V3_Traffic Impact Study.pdf Markup Summary

5 Provide Calibre at Woodmoor (P2214) has been submitted to county. Please review TIS for this project and incorporate into analysis as needed.

**WATERSIDE TOWNHOMES**  
 DEVIATION REQUEST - ECM SEC. 2.2.4.B.7.  
 FIGURE 2-17, TABLE 2-7  
 PCD FILE NO. PUDSP-22-009

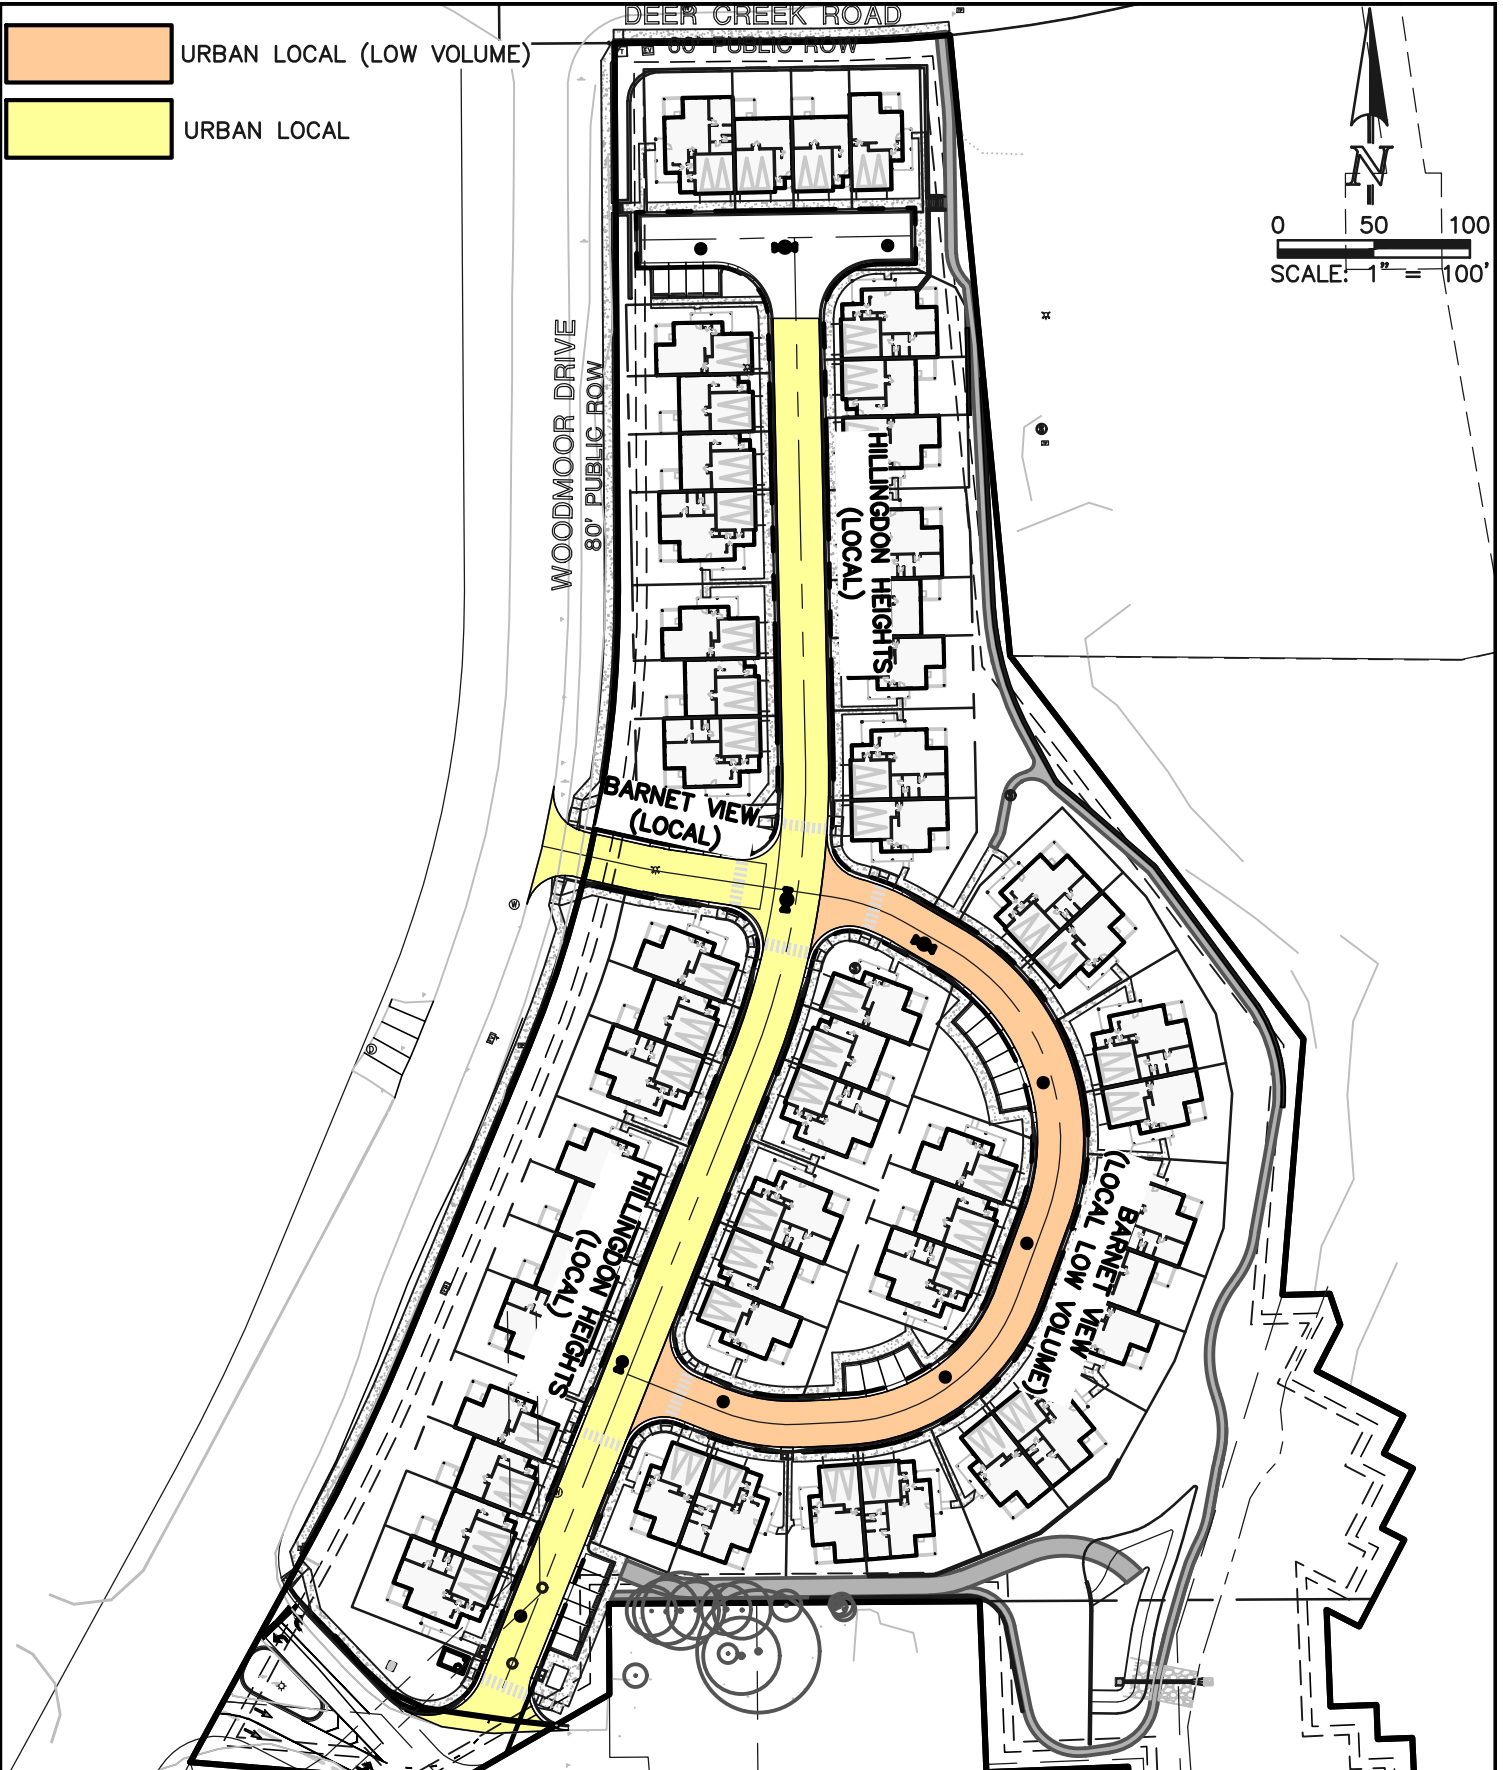
as Section (ECM Section 2.2.4.8.7, Figure 2-17, and 2-18) Provide description of why & what these deviations are being requested for.

Provide description of why & what these deviations are being requested for.
